Submission for Job: #6010 SSD 6010 - One Residential Building (Student Accommodation) within Darling Drive Plot

SSD 6010 - One Residential Building (Student Accommodation) within Darling Drive Plot

30 July 2013

Summary

SHADOW DIAGRAMS: PERSPECTIVE, SHOWING THE PEAK, WINTER SOLSTICE

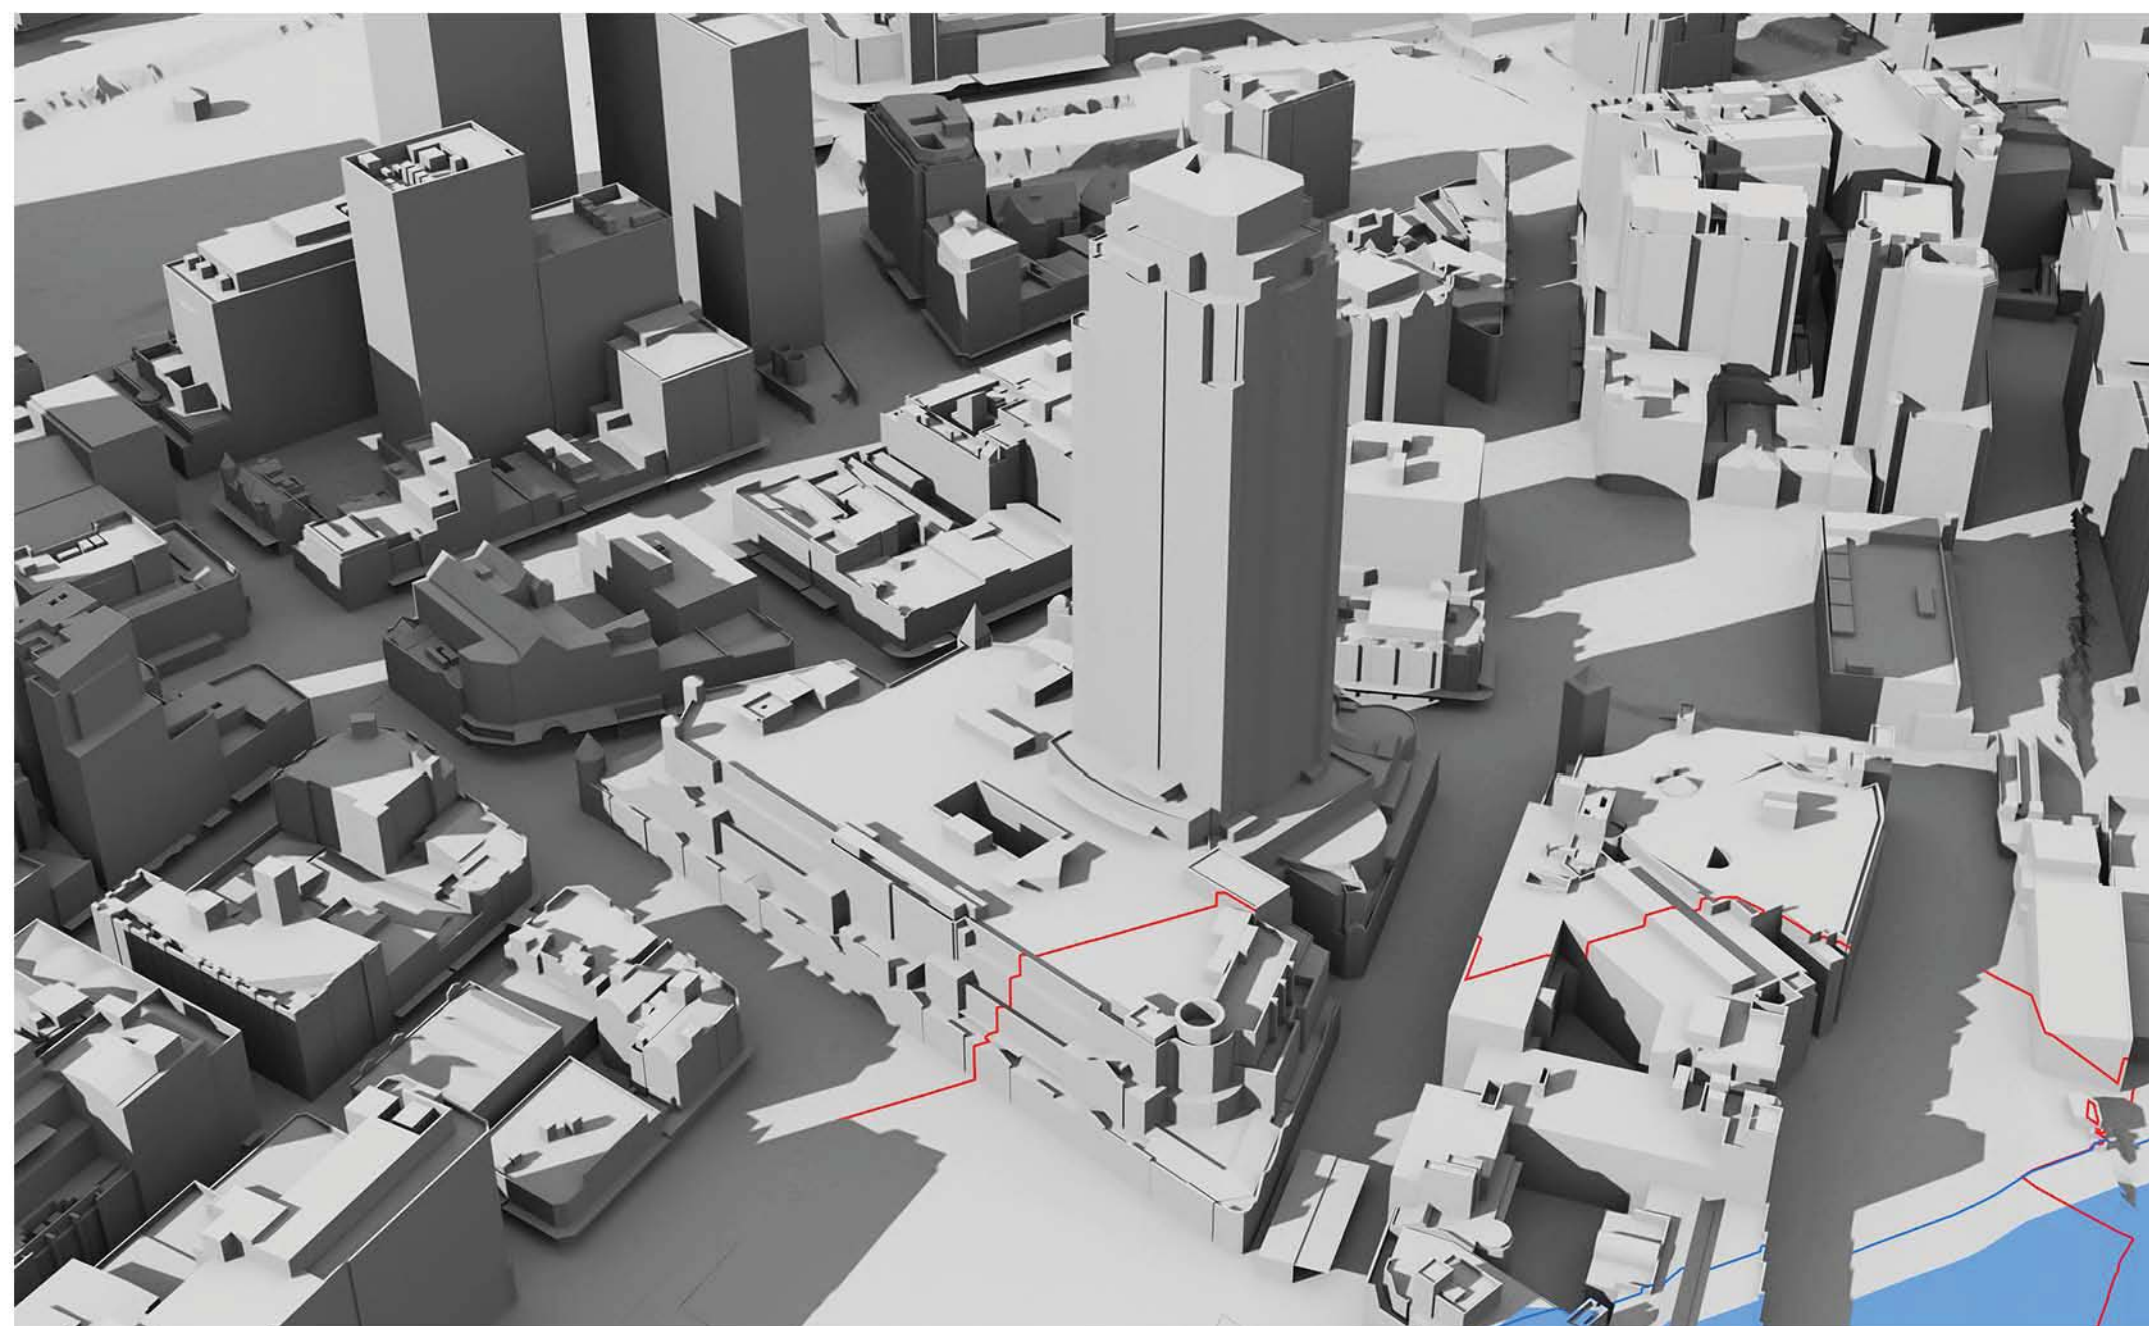
At 9am, 10am and 11am the west façade is totally in shadow due to other parts of The Peak building itself.

At 12pm there is still substantial existing shadowing on the west façade caused by the irregular shape of the west facade.

At 1pm the existing shadowing has been substantially removed, but not totally removed.

It can be concluded that some single aspect apartments on the west façade and some south-west dual aspect corner apartments currently receive less than 2 hours direct sunlight to habitable rooms and 50% of the private open space between 9am and 3pm on 21 June.

At 9am, 10am and 11am the west façade is totally in shadow due to other parts of The Peak building itself.

At 12pm there is still substantial existing shadowing on the west façade caused by the irregular shape of the west facade.

At 1pm the existing shadowing has been substantially, although not entirely, removed. However, overshadowing of lower levels of the west façade by the concept proposal parameter plan shadows for the N,NE and SE plots has already started.

By 2pm the existing shadowing has been totally removed. However, overshadowing of the west façade by the SSDA4 and SSDA5 buildings has appeared and risen further up the west façade than the concept proposal parameter plan shadows for the N,NE and SE plots, which is still present.

At 3pm, the proponent states correctly that 45-45% of the western façade is overshadowed by the SSDA4 and SSDA5 buildings.

It can be concluded that, as a result of combination of the proposed development with existing shadowing of the west façade, some single aspect apartments on the west façade and the south-west dual aspect corner apartments which currently receive less than 2 hours direct sunlight to habitable rooms and 50% of the private open space between 9am and 3pm on 21 June will suffer additional overshadowing. It is beyond our skills to count the number of such apartments. We note that the proponent has made no attempt to do so.
